18 October 2019

NSW Department of Planning, Industry & Environment
GPO Box 39
SYDNEY NSW 2001

RE: MOOLARBEN COAL PROJECT STAGE 1 MODIFICATION 15 (05_0117 MOD 15)

**Figure 2.2 – Location of Surface Infrastructure associated with MOD 15**

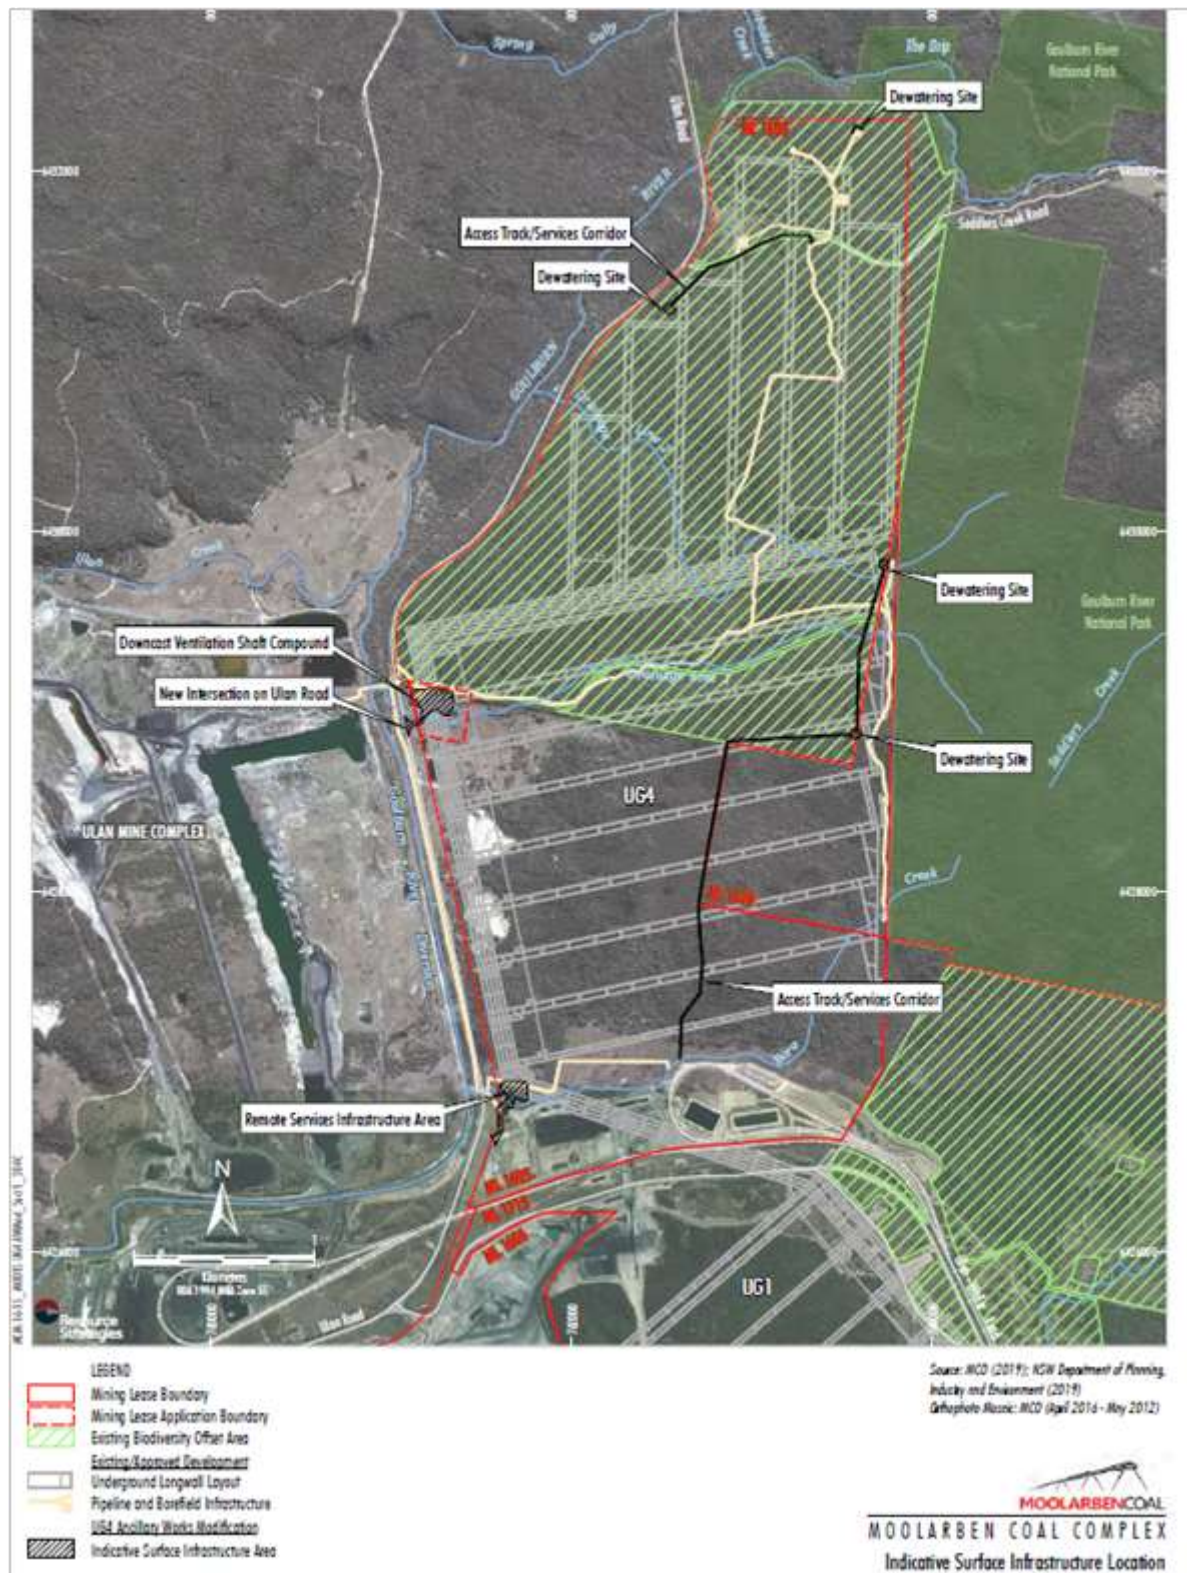
Council requests that the proposed intersection with Ulan Road be designed in accordance with *Guide to Traffic Management Part 6: Intersections, Interchanges and Crossings* (Austroads, 2017), and that the proponent consult with NSW Roads and Maritime Services and Council to obtain all relevant approvals for the works to be undertaken. All works will be at the full cost of the proponent.
